**Application no:** H16/0414/03  
**Original Applicant:** Miss C & Miss L Drury  
Southfields  
Clay Lake  
Spalding  
Lincs PE11 2QG

**Description:** New chalet bungalow and detached car port

**Location:** Plot adj. Southfields  
Clay Lake  
Spalding

**Amendment:** Window next to front door changed to rectangular  
Dwg. no. 449-01 B

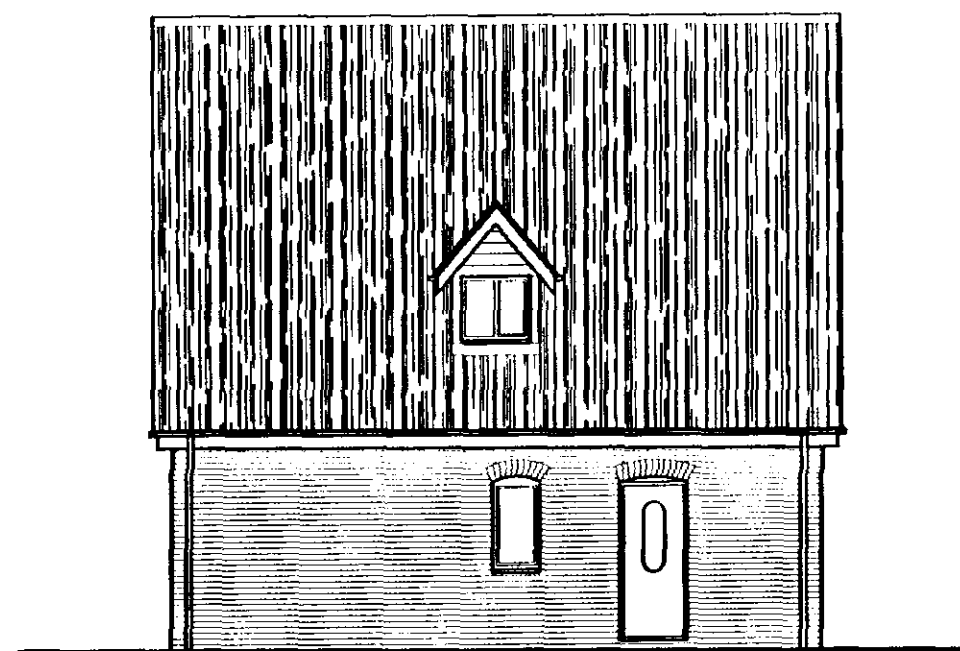
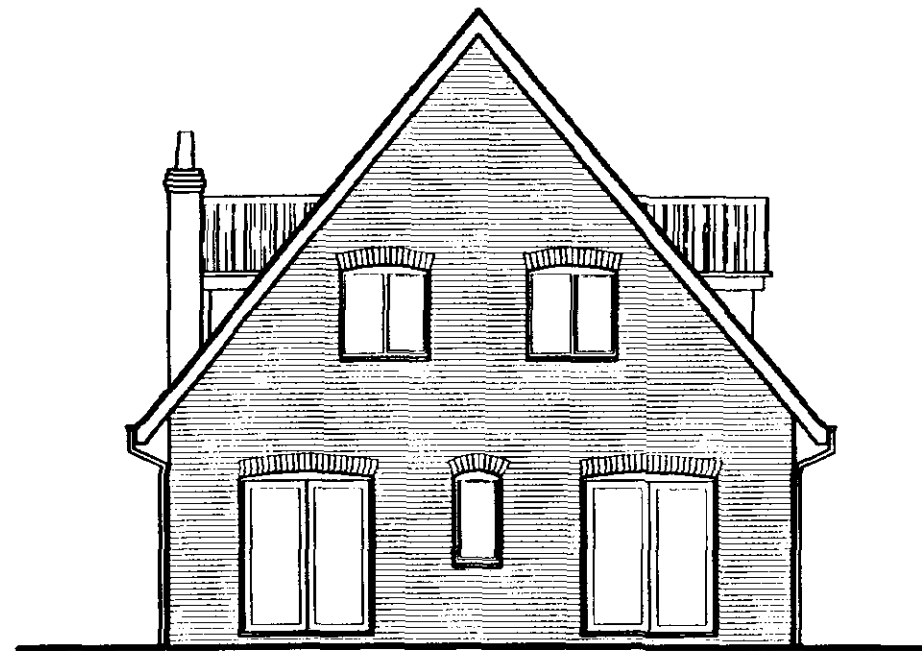
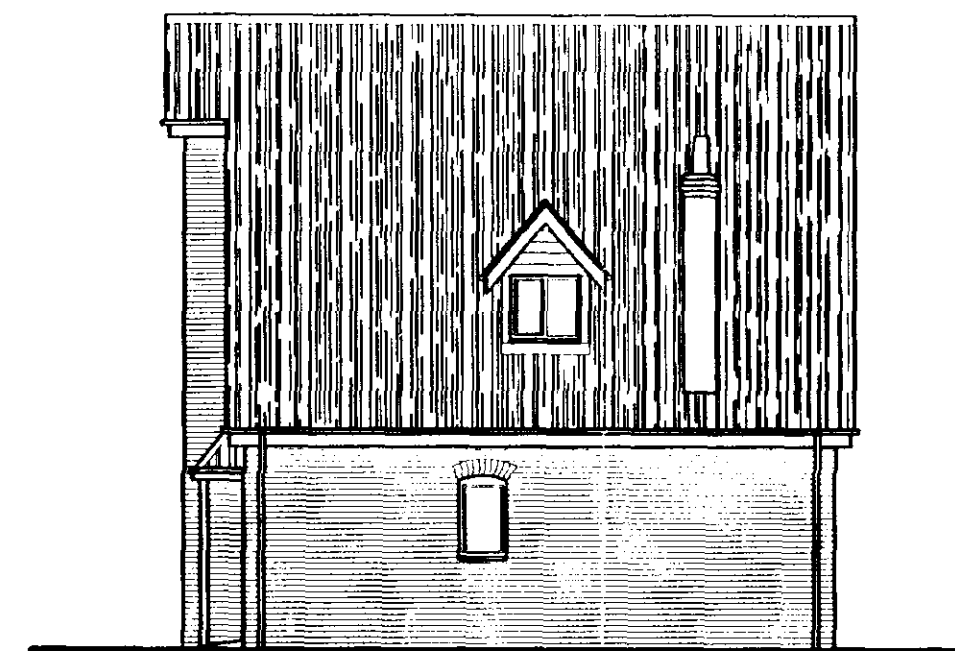
WINDOW NEXT TO  
FRONT DOOR CHANGED  
TO RECTANGULAR.

Following my client's recent telephone conversation with Mr Roberts, I have now been asked to submit an additional amendment showing a rectangular window next to the front door (previously circular) and therefore enclose the following in respect of a Planning Amendment:
